CITY OF ALBUQUERQUE

December 10, 2024

RE: 9324 Susan Avenue SE
Grading & Drainage Plan
Engineer's Stamp Date: 10/17/24
Hydrology File: L20D079

GRADING & DRAINAGE PLAN
SCALE: 1" = 10'-0"

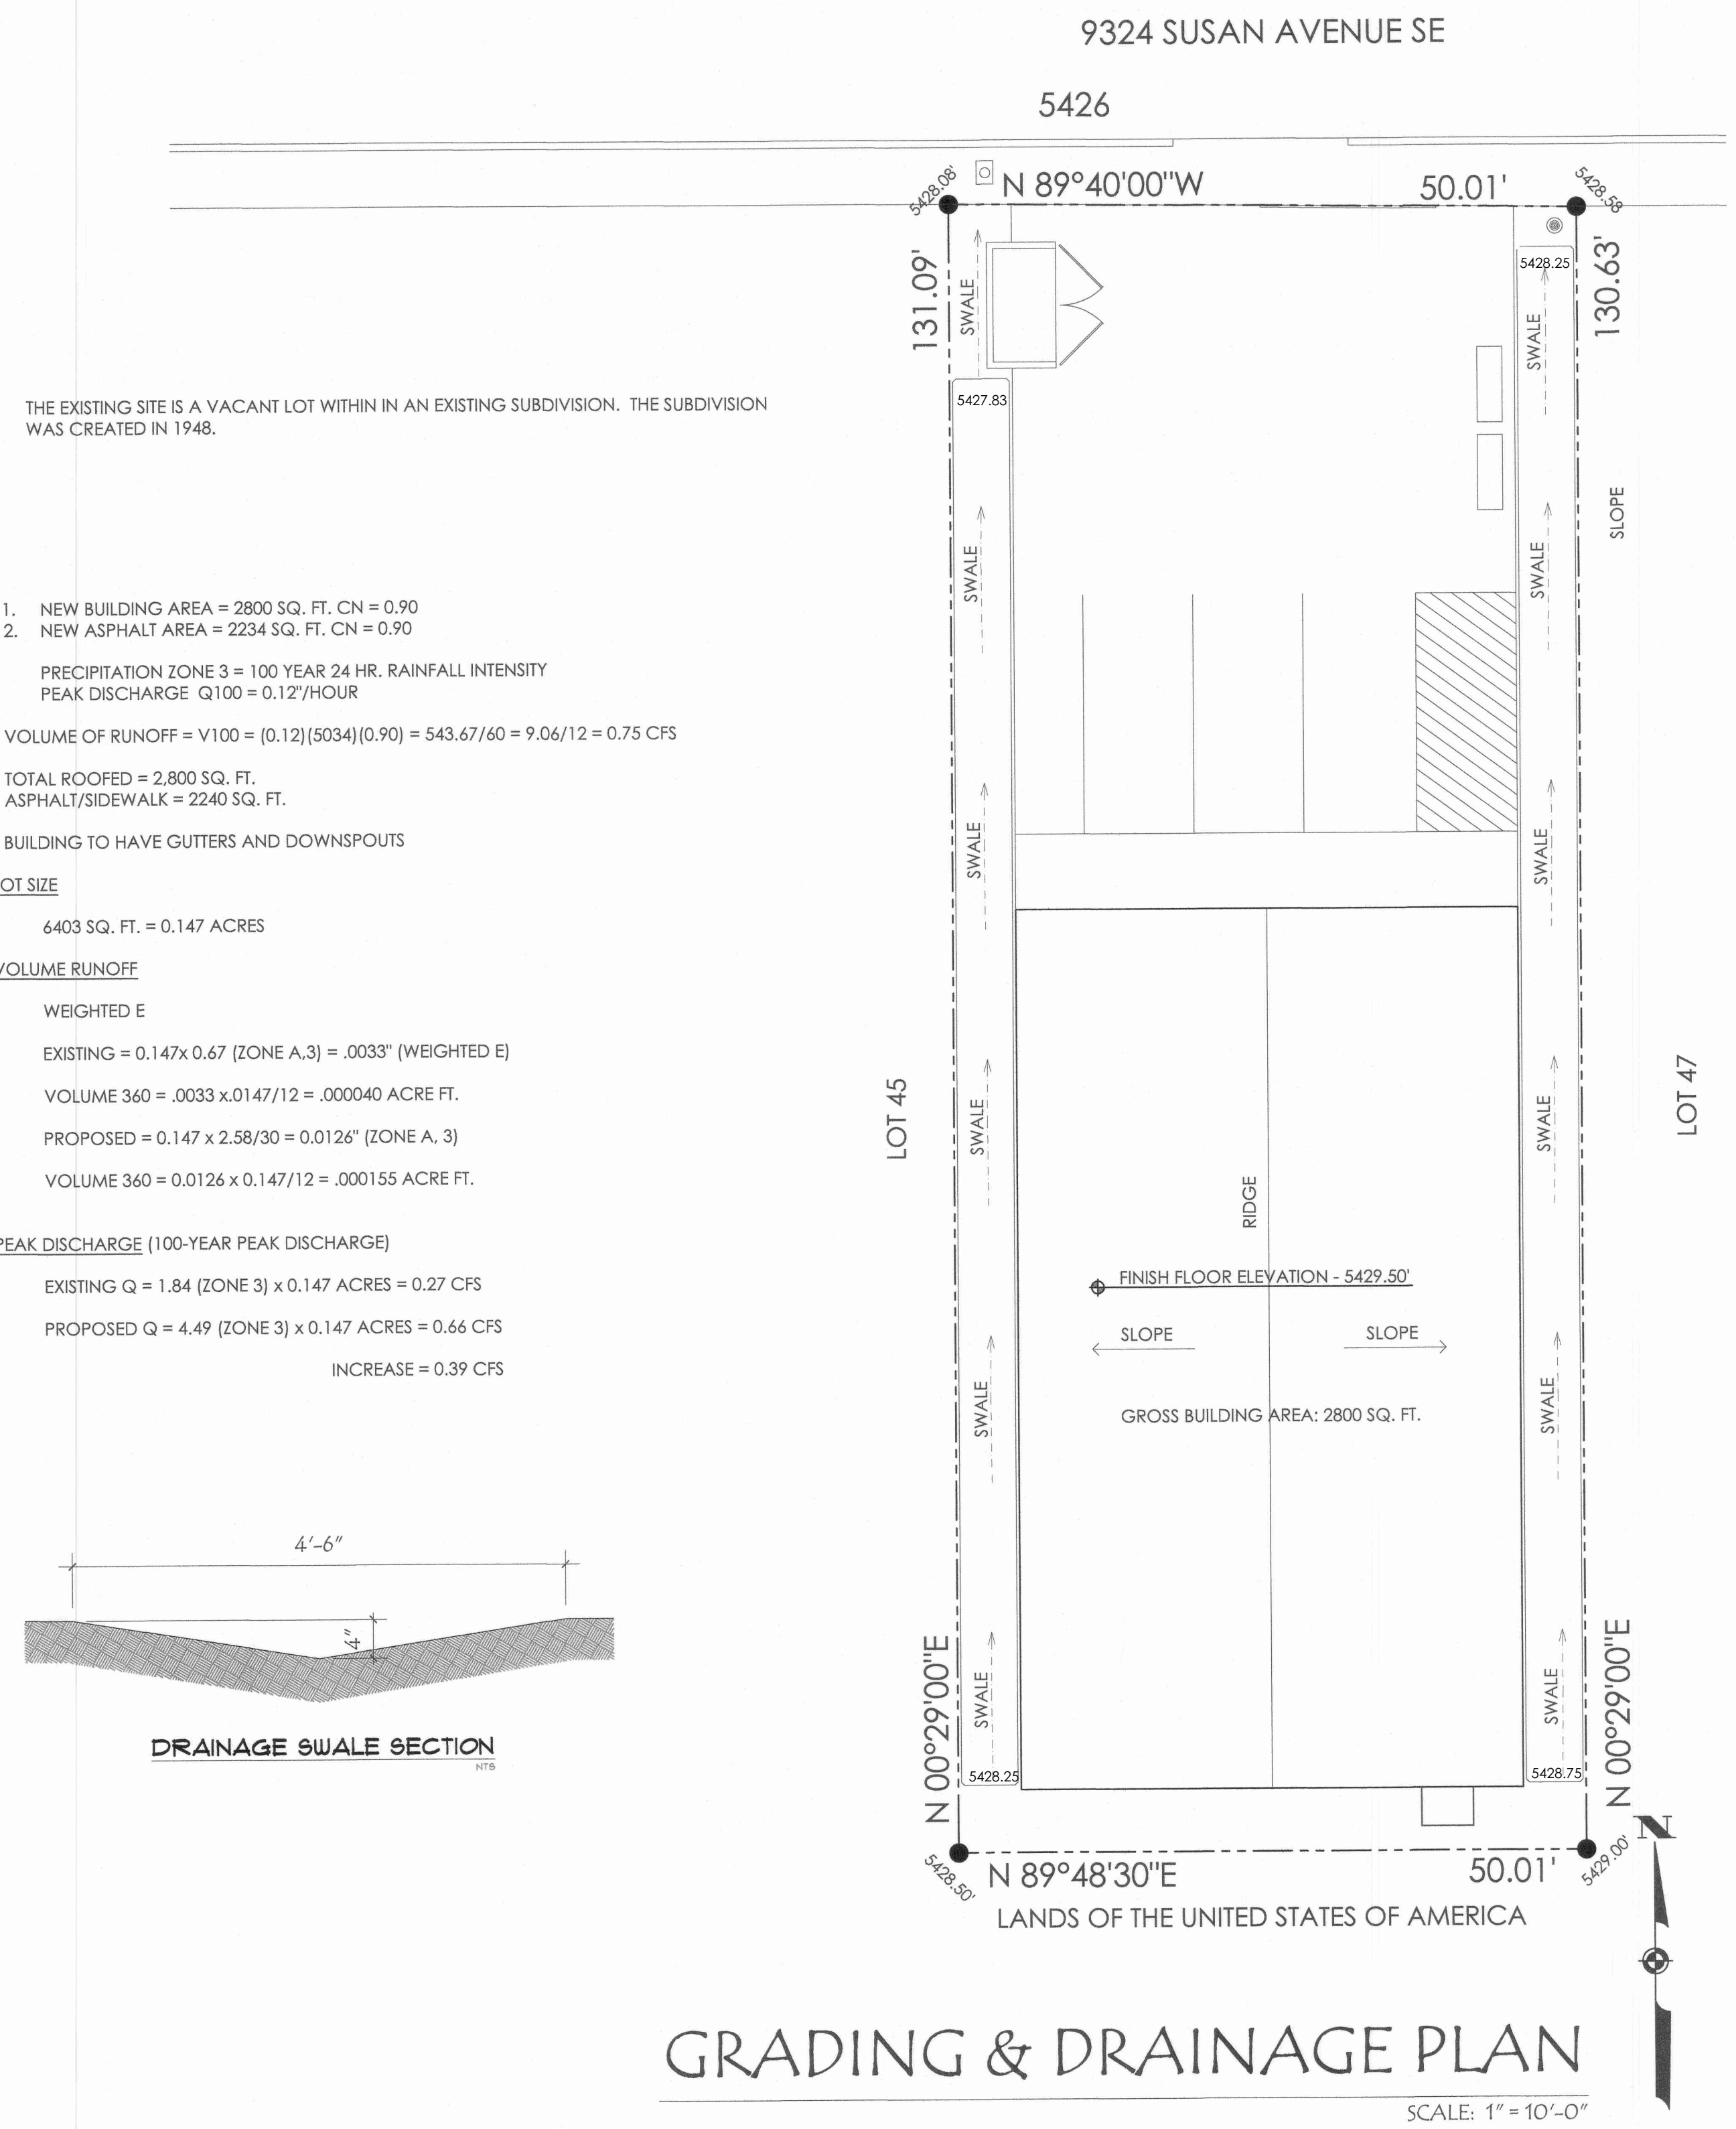
3. Per the DPM Section 6-14(B)(6), please provide a brief yet comprehensive discussion of the Developed Conditions.
4. Provide management onsite for the Stormwater Quality Volume (SWQV) in accordance with the new drainage ordinance, § 14-5-2-6 (H). Please show the top and bottom of the ponds along with the volume for each pond. The onsite drainage should be directed to these ponds prior to being collected in a private unground drainage system. Please follow the DPM Article 6-12 Stormwater Quality and Low-Impact Development for the sizing calculations. To calculate the required SWQV, multiply the impervious area draining to the BMP by 0.42 inches for new development sites. The calculations of both the required and the provided volume of each BMP must be shown on the Grading and Drainage Plan. Each

BMP should be labeled on the Grading and Drainage Plan with the required SWQV and associated water surface elevation and the 100-year water surface elevation. Landscaping of surface BMPs is also required to be noted on the Grading and Drainage Plan.

5. Please provide the SWQV calculations for each basin draining to each pond. The stormwater quality ponds need to be sized for the areas draining to them.
6. If requesting a Waiver of Management Onsite, the following conditions of the new drainage ordinance (enacted 10/2/18) must be demonstrated on the plan (§ 14-5-2-6 (H)):

7. Please add a note which states, "The Owner has elected to pay the Payment in Lieu for the required Stormwater Quality Volume."
8. Please show the calculation for the Payment-in-Lieu.

9. Please use the procedure for 40 acre and smaller basins as outlined in Development Process Manual (DPM) (signed 06/08/20) Article 6-2(a). Please provide both the existing conditions and proposed conditions for the 100-year 6-hour storm event.

10. Provide existing site topography and label existing and proposed contours. Since the site is extremely flat, please provide spot elevations in enough density to verify the drainage areas and outfalls that you have indicated. Also include the finished floor elevation of the buildings.

11. Per the DPM, the following must be on the Grading Plan. Please note the Grading Plan must be a stand-alone construction document.
 - a. Please provide a Vicinity Map. This can be downloaded in pdf format from the City of Albuquerque's website.

- b. Please provide the Benchmark information (location, description and elevation) for the survey contour information provided.
 - c. Please provide the FIRM Map and flood plain note with effective date.
 - d. Please provide a legal Description of the property.
12. Per the DPM Section 6-14(B)(3), please provide the following information related to Flood Hazard Zones:
- Identify proximity of site to a designated Flood Hazard Zone.
 - Provide reference to the above referenced Flood Hazard Zone.
 - Identify whether or not the site drains to or has an adverse impact upon a designated Flood Hazard Zone.
 - Include a copy of the relevant FEMA Flood Insurance Rate Map (FIRM) or Flood Boundary and Floodway Map with the site clearly identified along with all affected Flood Zones.
